From: Anita Gardner <Anita.Gardner@arun.gov.uk>
Sent: 16 February 2021 10:08
To: Planning.Responses <Planning.Responses@arun.gov.uk>
Subject: FW: A/193/20/PL - Addition to Objection already submitted

From: Steven Mountain [REDACTED]
Sent: 15 February 2021 10:45
To: Anita Gardner <Anita.Gardner@arun.gov.uk>
Subject: A/193/20/PL - Addition to Objection already submitted

Proposed Street Scene (Scale 1:200)

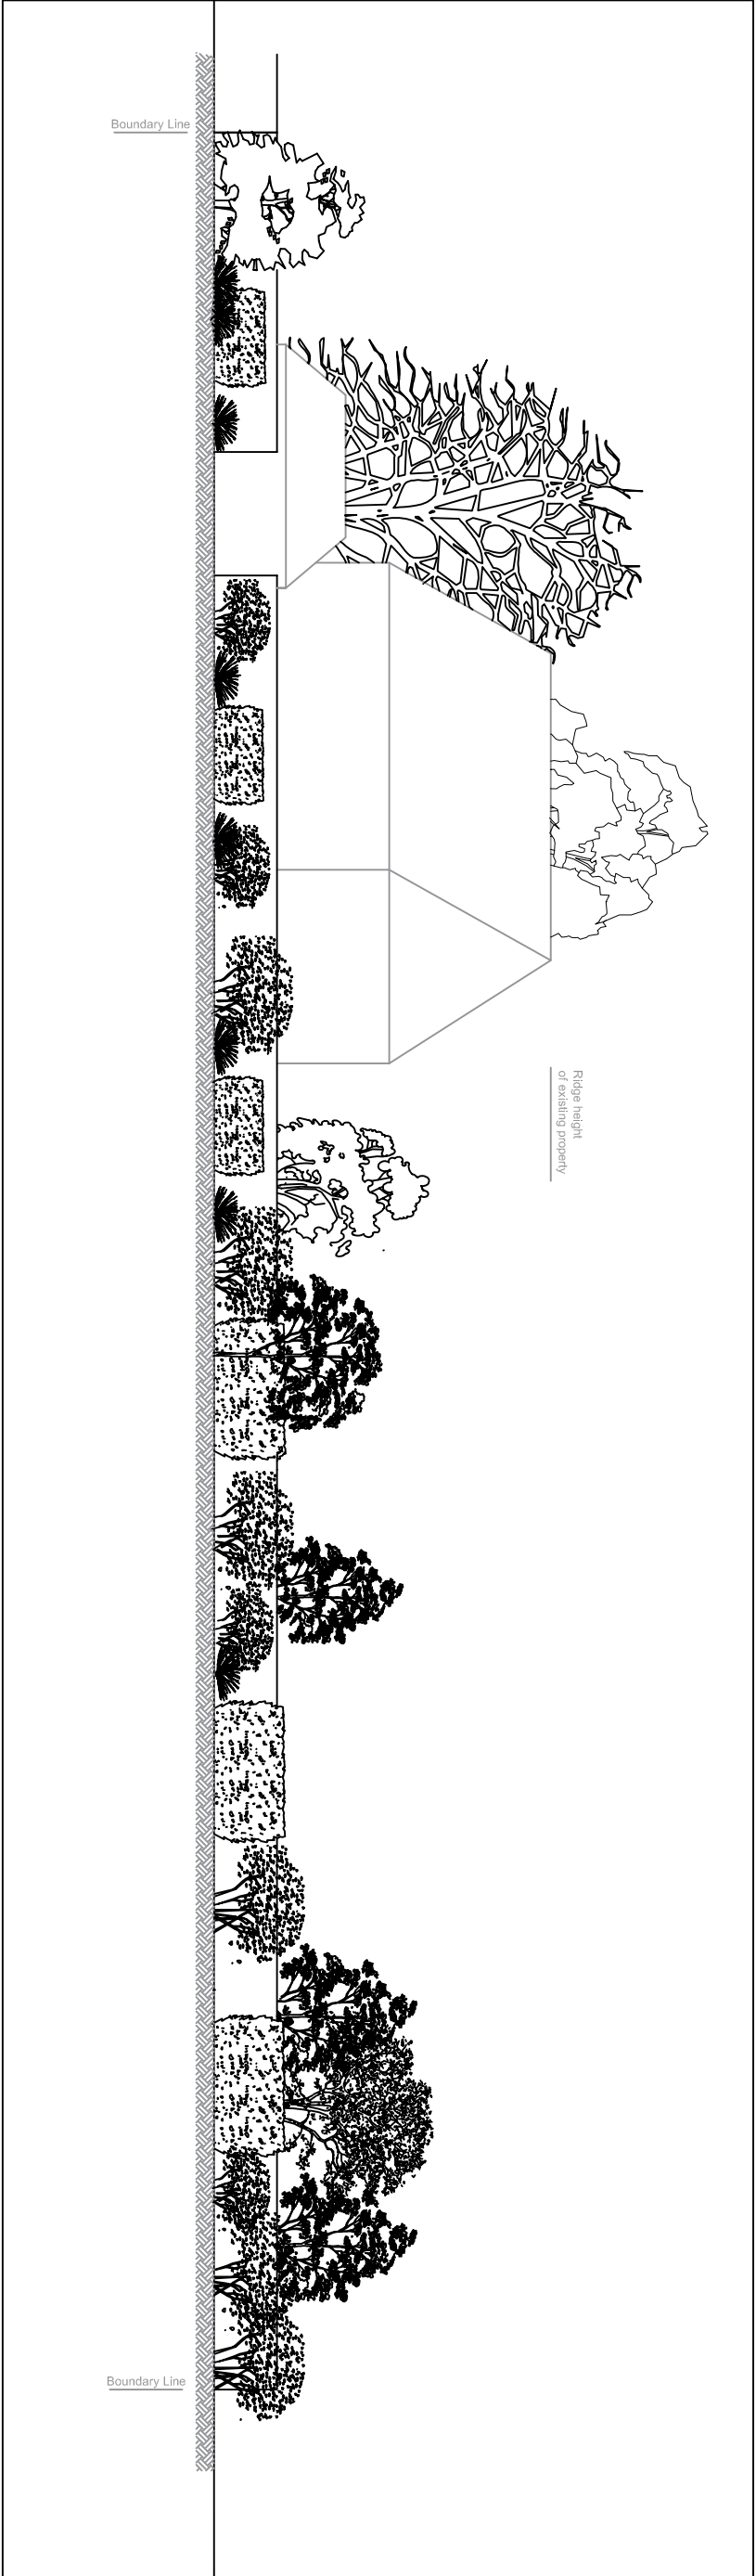
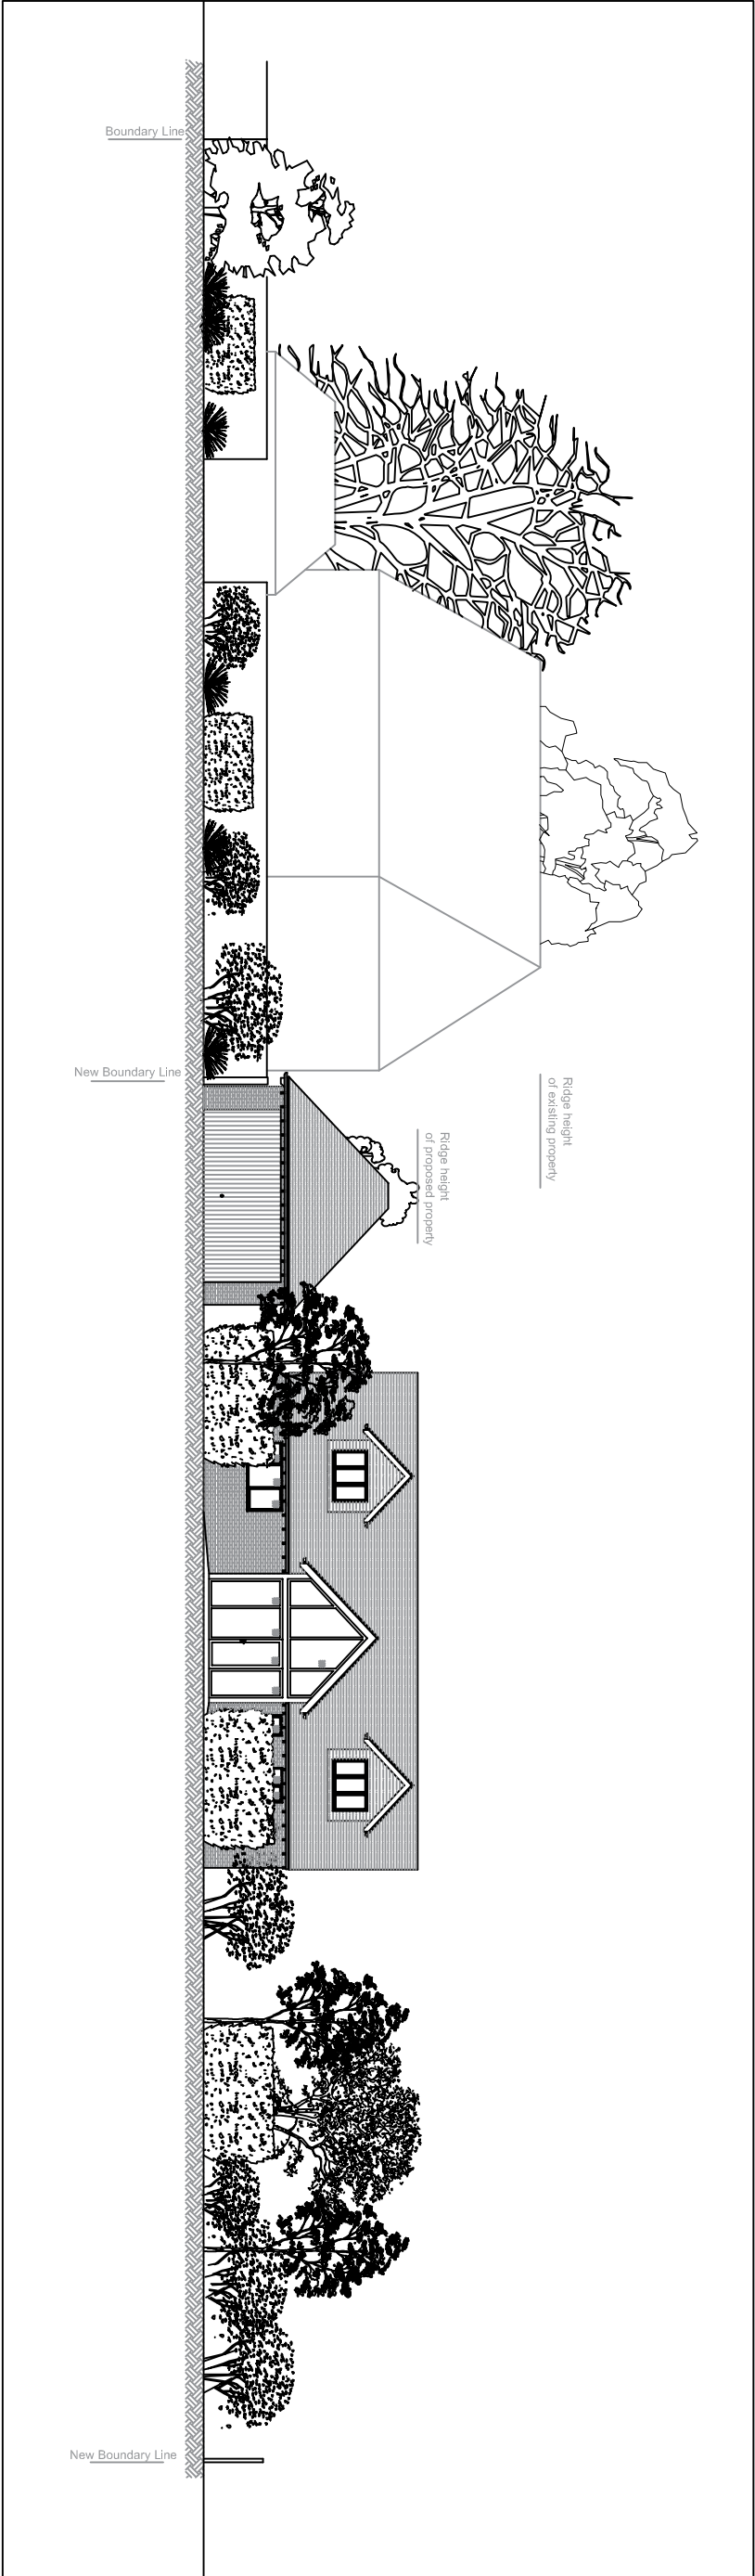
This further evidences the effect of any house construction on this site and how dominant such a structure would appear.

Revision:	A	Dec 2020	Dimension added
address	Ham Manor Cottage, Ham Manor Way, Worthing, West Sussex		
project	Proposed construction of 3 bedroom detached property with detached double garage		
title	Proposed Block Plan		
scale	date	dwg no.	revision
1:200 on A4		2020.275.02	A

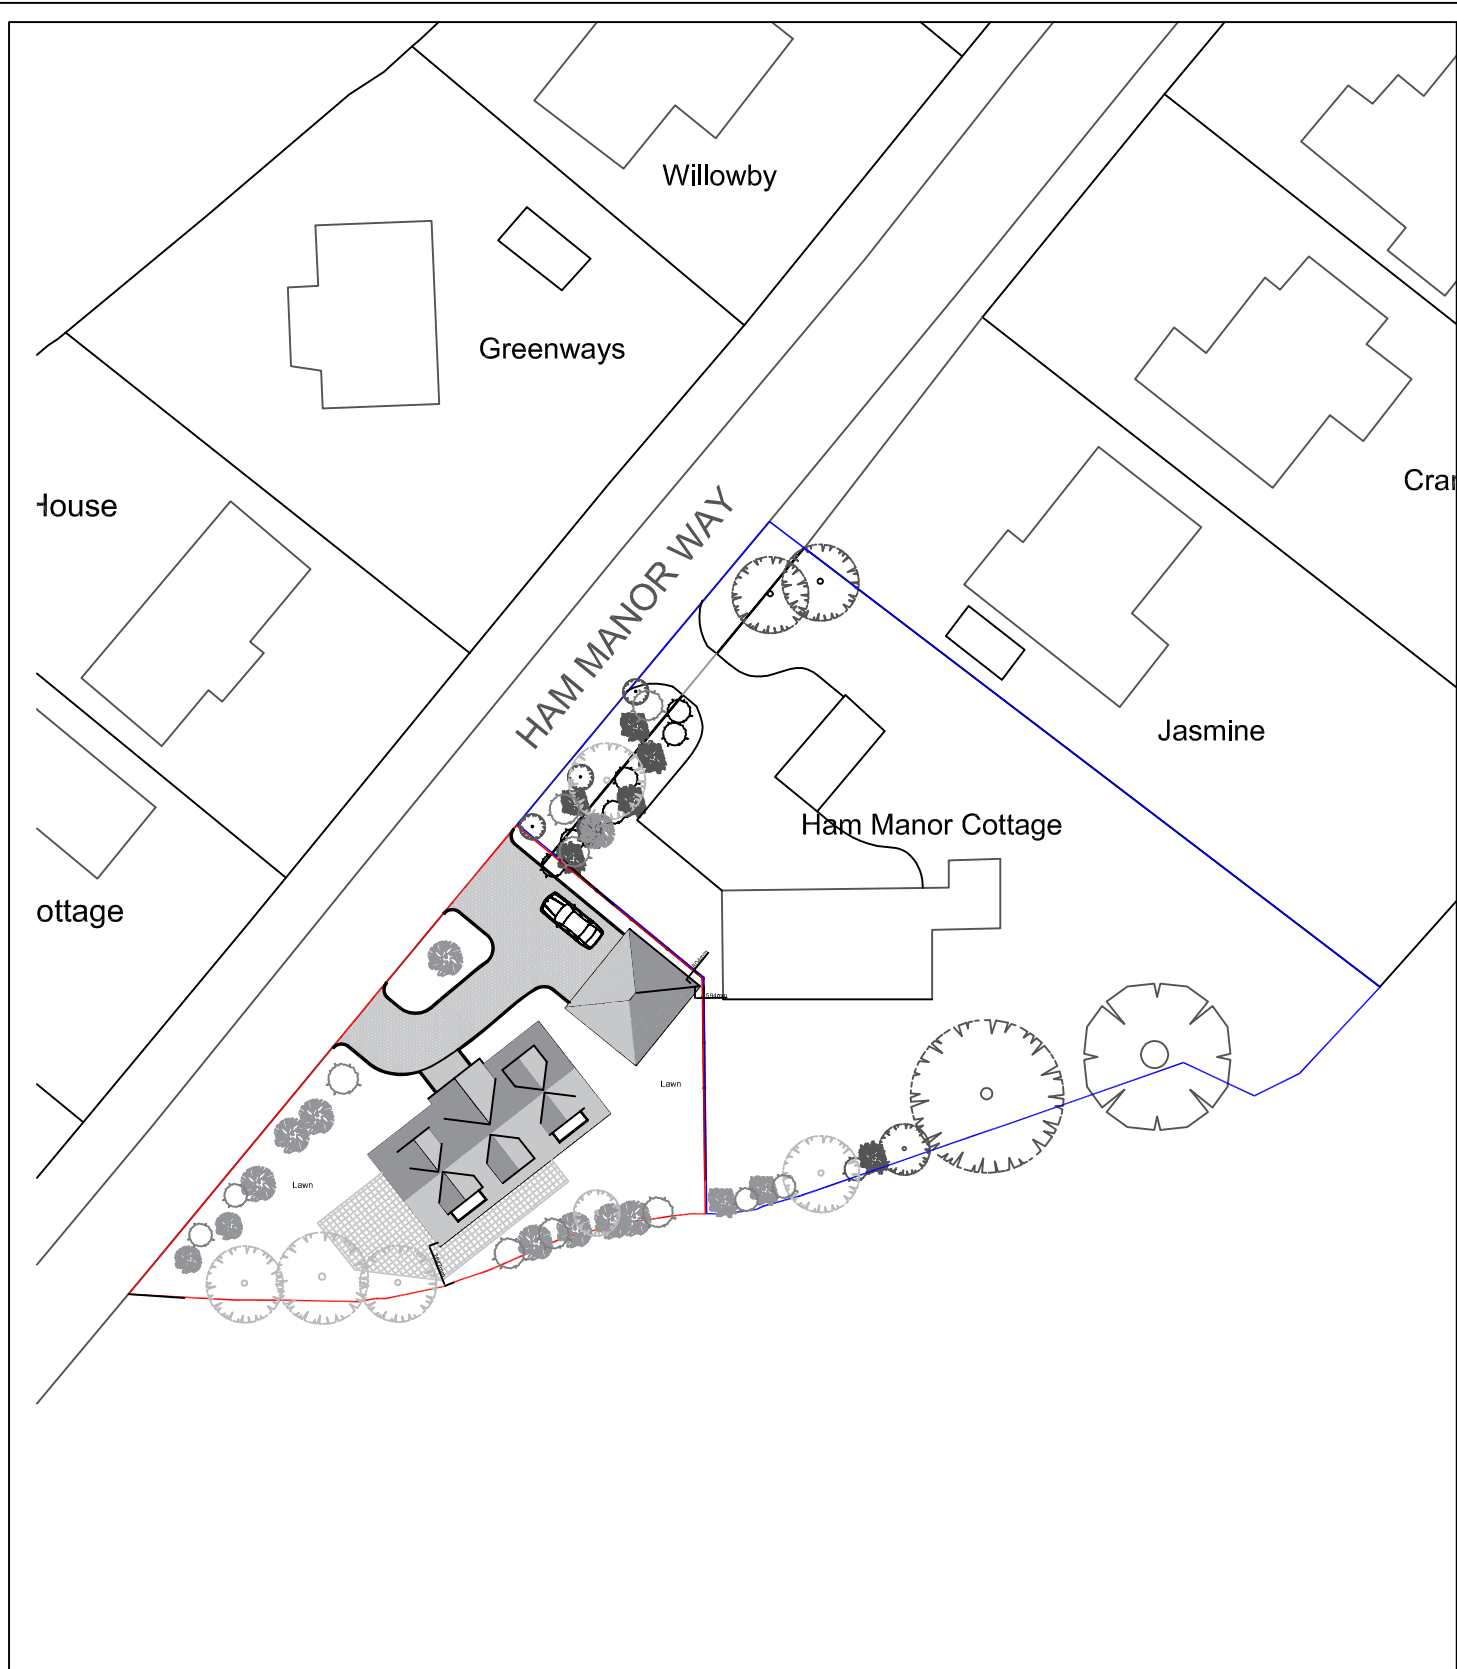
In addition the application shows an in/out drive which would mean the removal of large parts of the boundary wall and adjacent vegetation.
